Subject: Request for Advice - EIS - Mowbray Road, Lane Cove North, Affordable Housing (SSD-71687208)

Thank you for your referral received 25 October 2024, requesting advice from the Biodiversity, Conservation and Science Group (BCS) of the NSW Department of Climate Change, Energy the Environment and Water (DCCEEW) on the State Significant Development Application (SSD-71687208) located at 618-624 Mowbray Road and 25-29 Mindarie Street, Lane Cove North.

BCS comments on the Environmental Impact Statement for Mowbray Road, Lane Cove North, Affordable Housing (SSD-71687208)**Flood Risk Management**

UPPER GROUND FLOOR PLAN

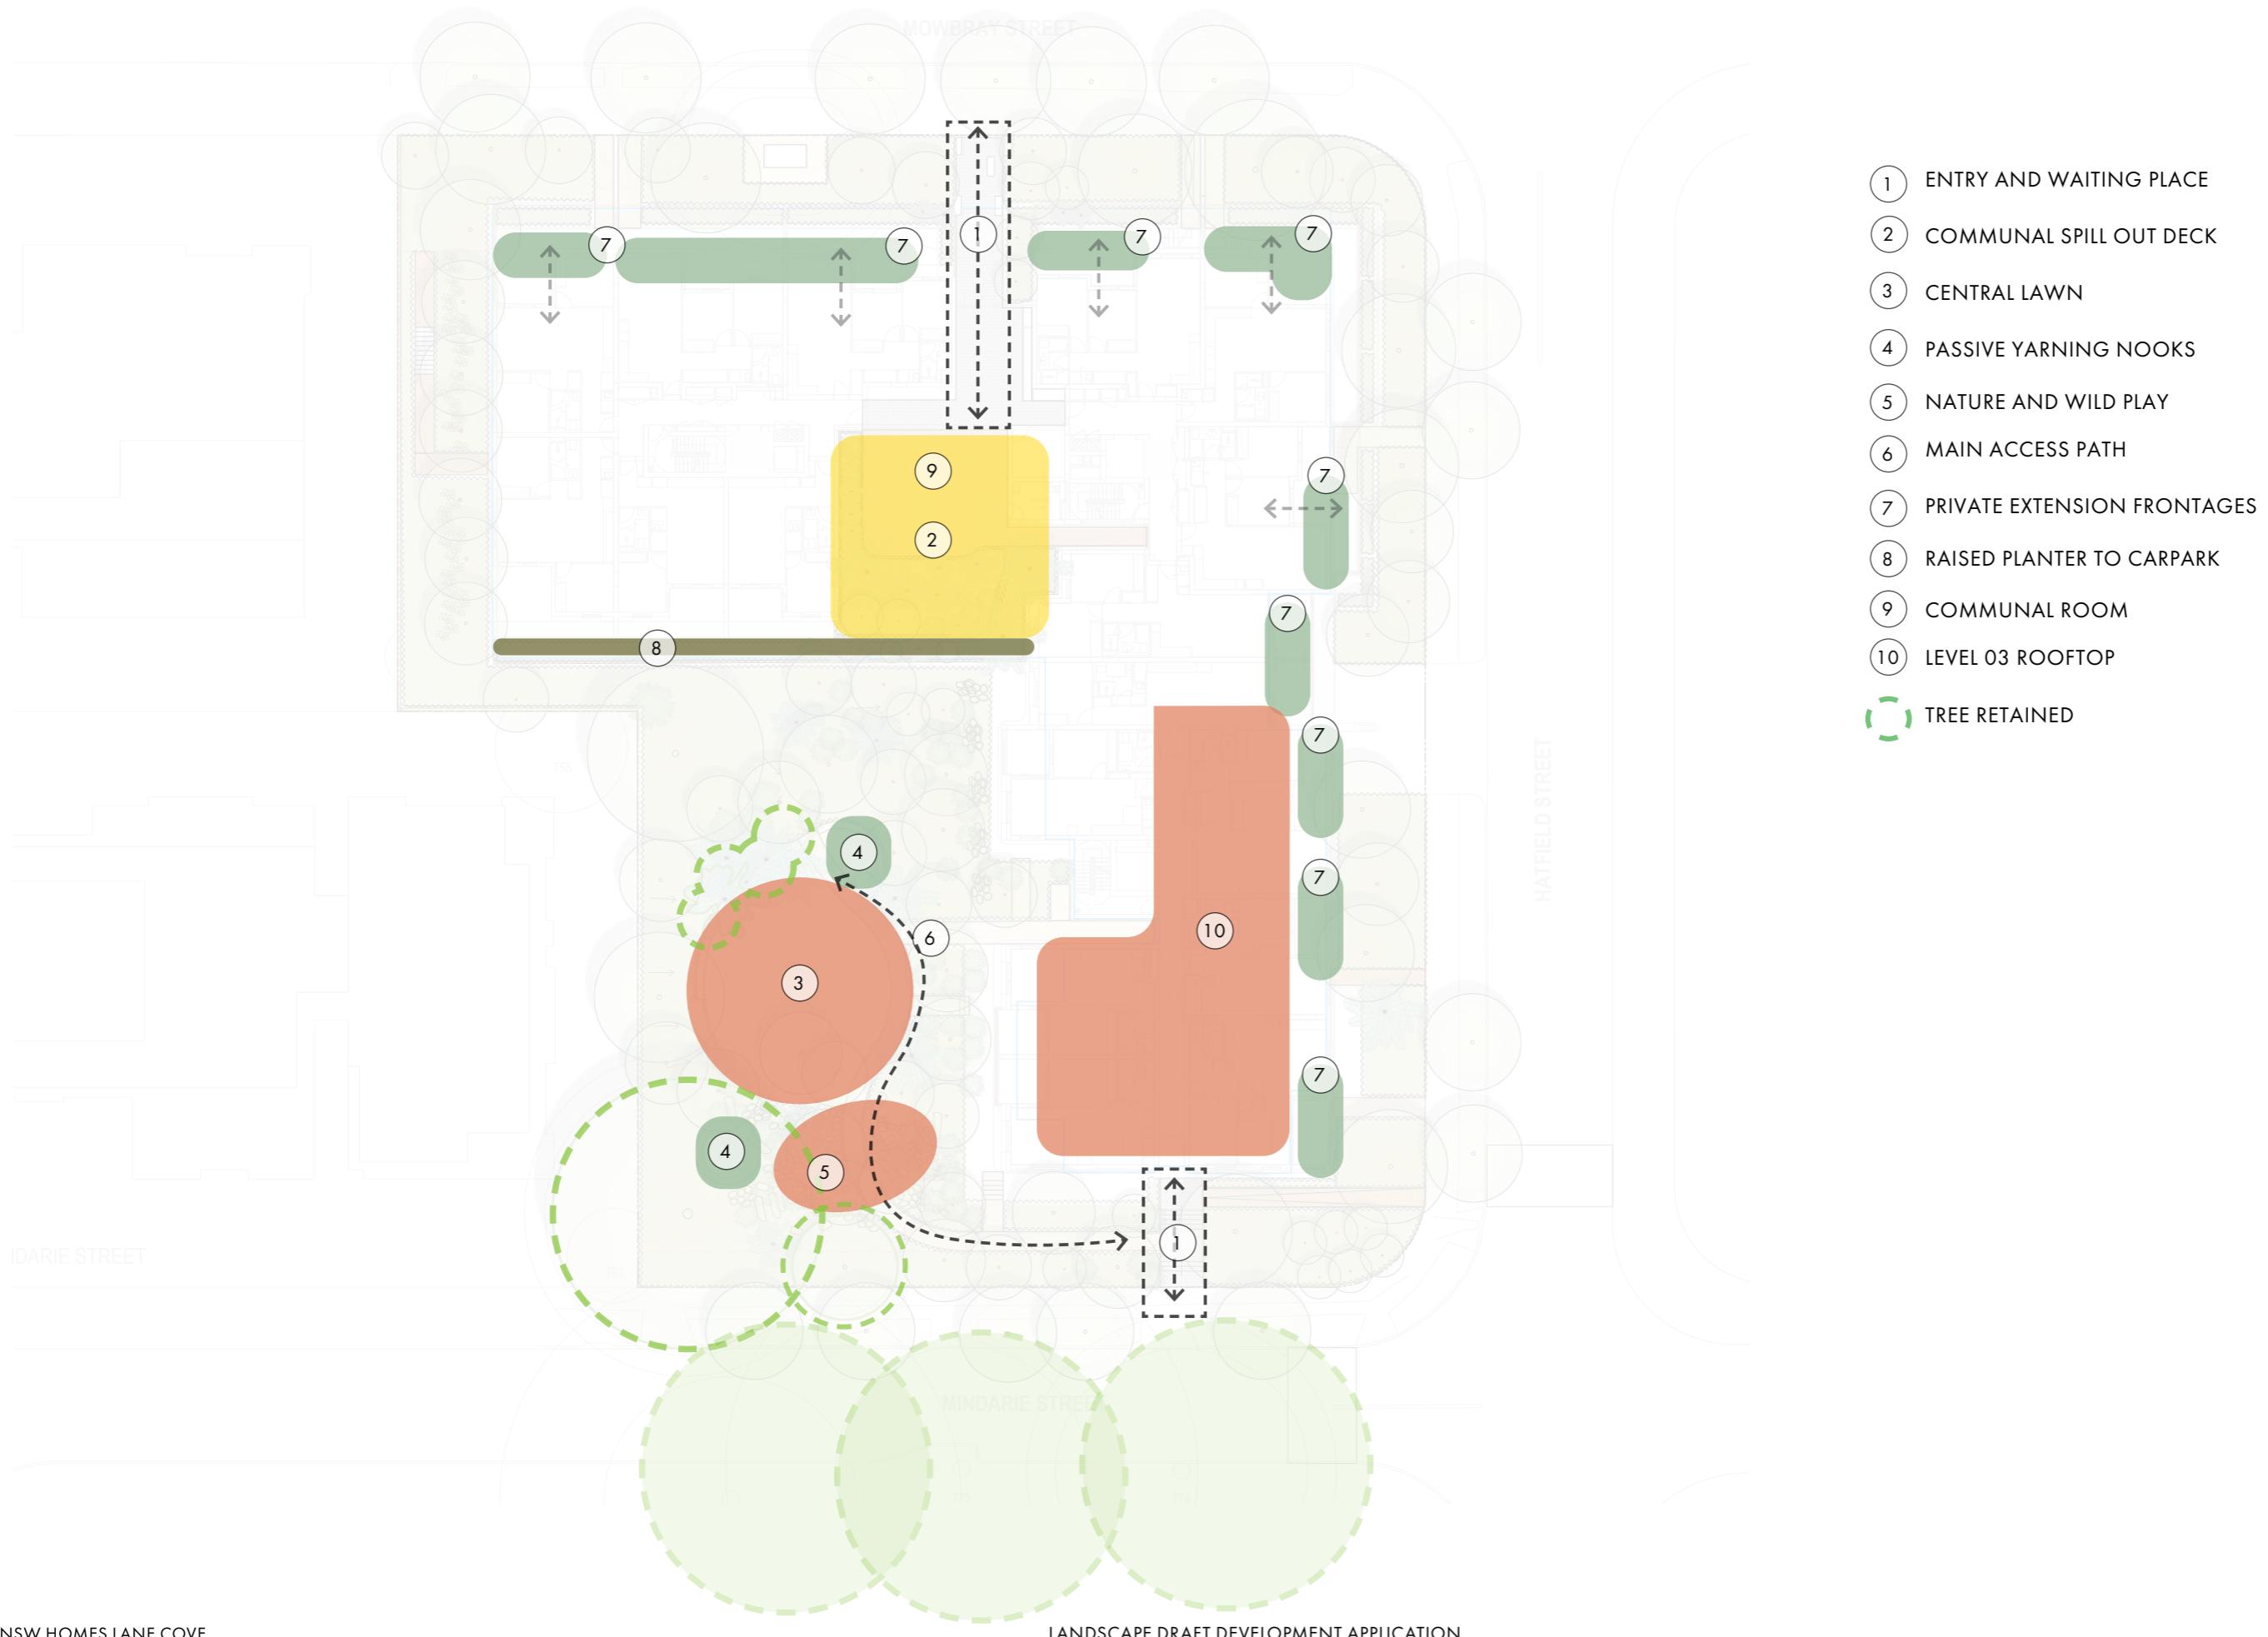
<p>5. Requirement for access for maintenance and reconnection of existing pipework is unclear</p>	<ul style="list-style-type: none"> The relocated pipework is required to be contained within a 2.5 m wide easement for maintenance by Council. It is unclear how this has been accommodated in the landscaping plan and part of the pipework passes under the corner of the building where concrete encasement is proposed. For the existing case pipework is shown entering the existing pipe from a westerly direction towards the rear boundary of the adjoining site (31-29 Mindarie Street). It is not shown how this connection is made in the diverted pipe system. <p>Recommendation 5</p> <p>Council stormwater engineers should be consulted regarding easements and access to ensure this can be achieved. Engineering requirements for the flow path and pipe infrastructure will then need to be co-ordinated with the landscape design to see how much of the commitments to tree planting and soft landscaping can still be achieved.</p>

- It is noted that there are design changes that have not been considered with the addition of a rock channel for flood management.
- The BDAR refers to 0.06ha of PCT 3136, conforming to the critically endangered ecological community (CEEC) Blue Gum High Forest (BGHF), being cleared, and 0.02 being retained but modified, for a total of 0.08ha on the subject land, which is the entirety of PCT 3136 on the subject land. The BAM Credit Summary Report attached in the report has input 0.08ha to be cleared, generating 1 ecosystem credit, therefore even if there are changes to the vegetation clearance to accommodate the rock channel, it would not significantly alter the impact to the CEEC BGHF, or the total credits required.
- The rest of the report has provided adequate information, and no further information is required.

Overland Flow Path Sections

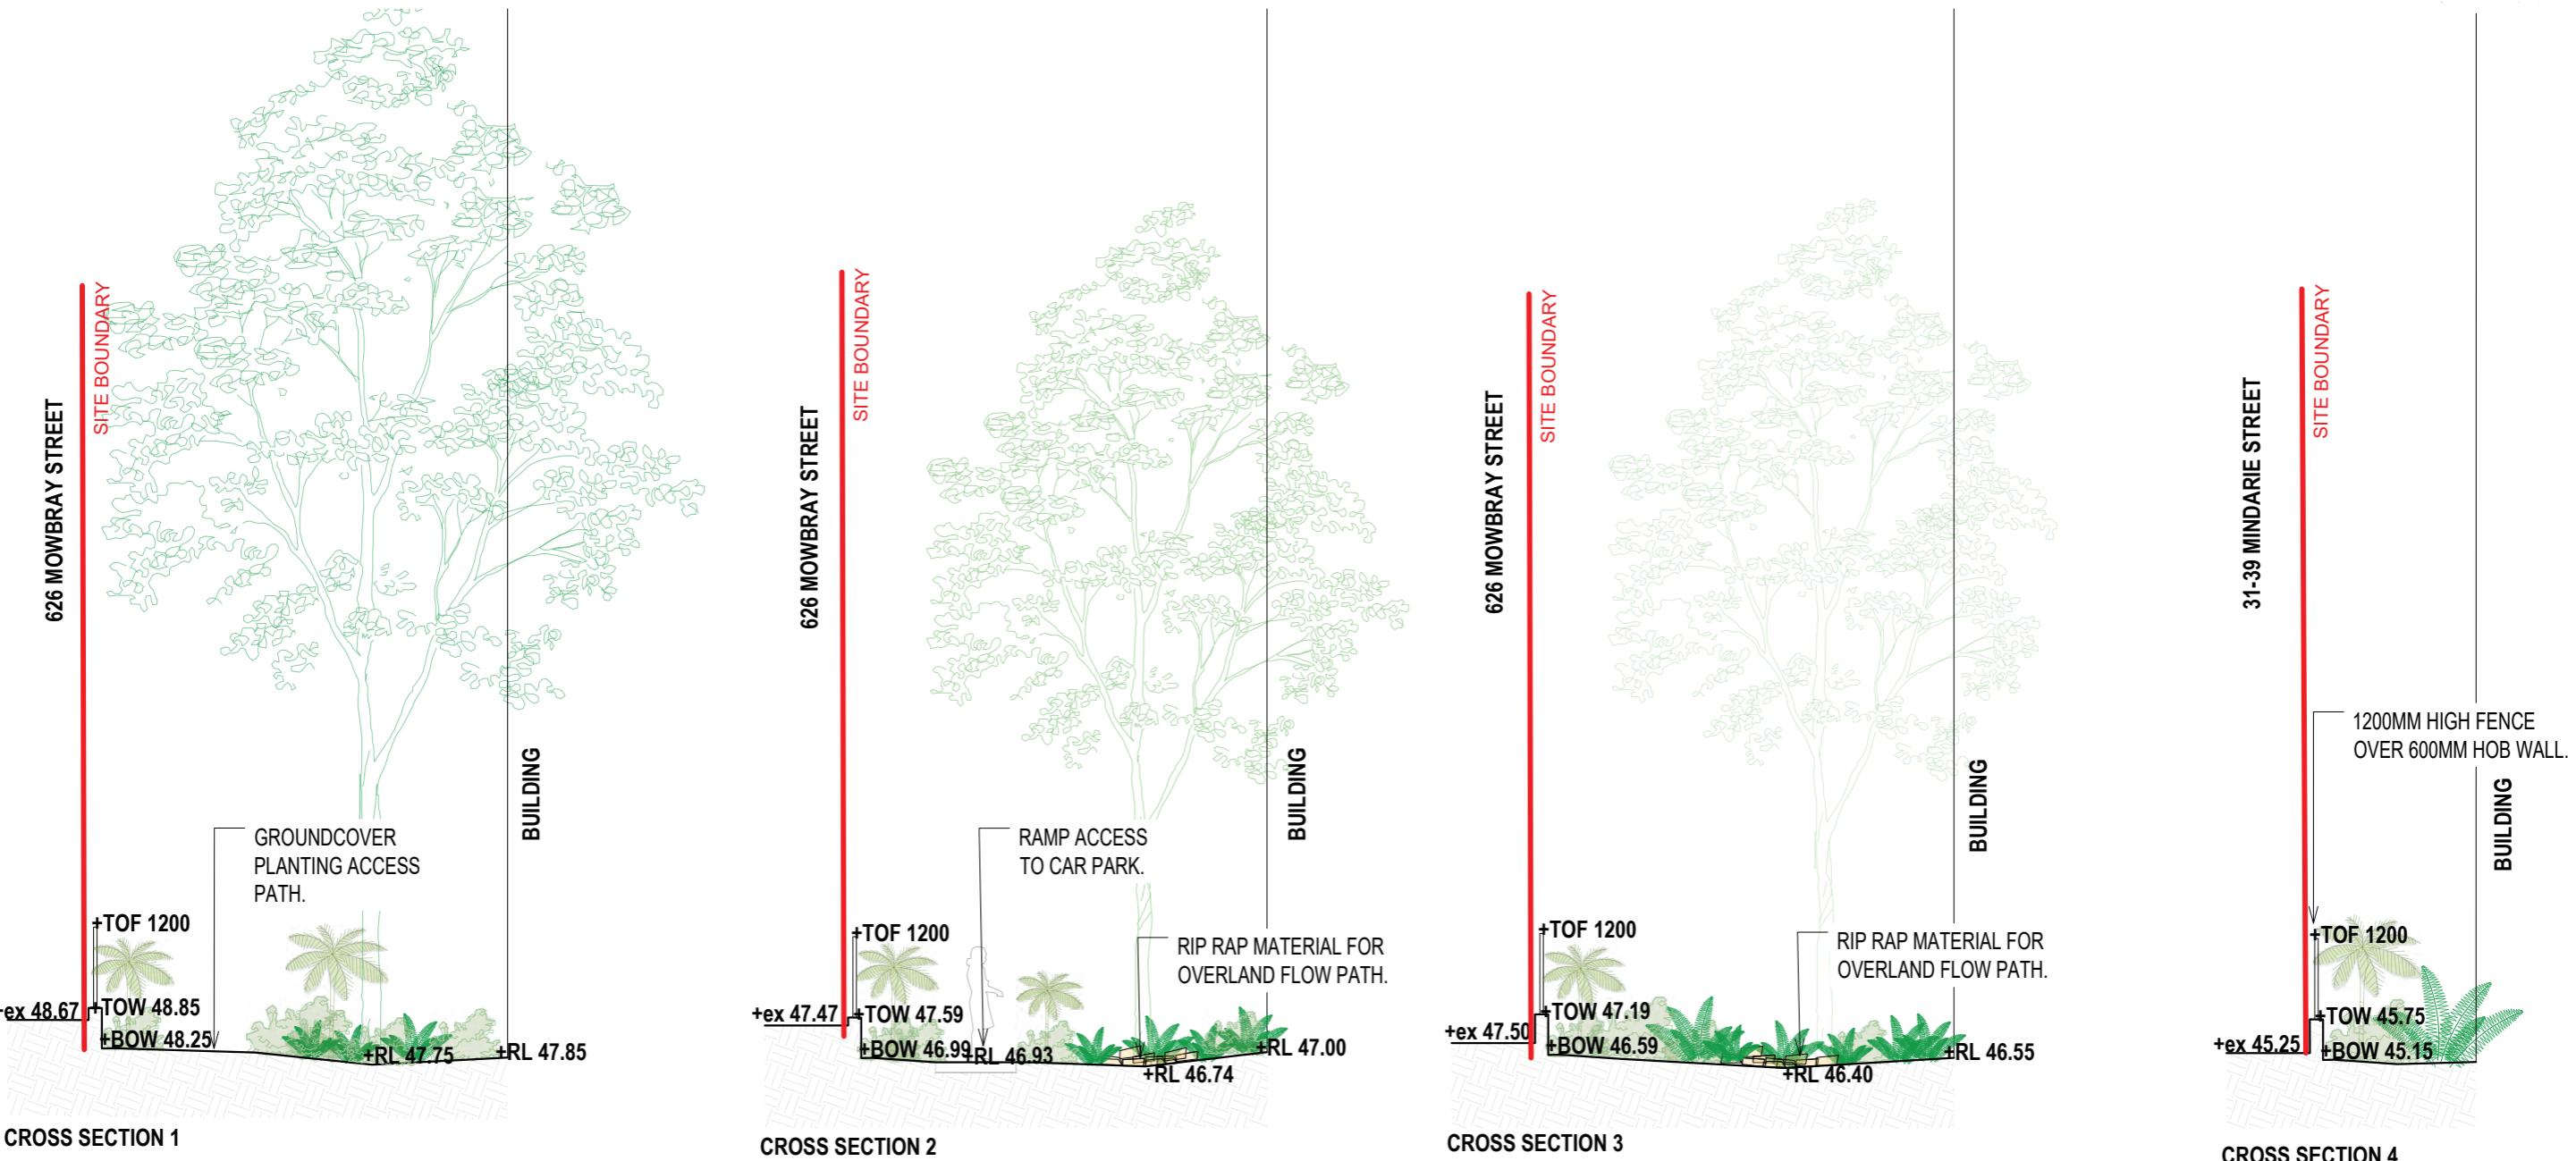
Both the pipe and the flow path will be much closer to boundaries than the previous infrastructure and the overland flow path is highly constrained.
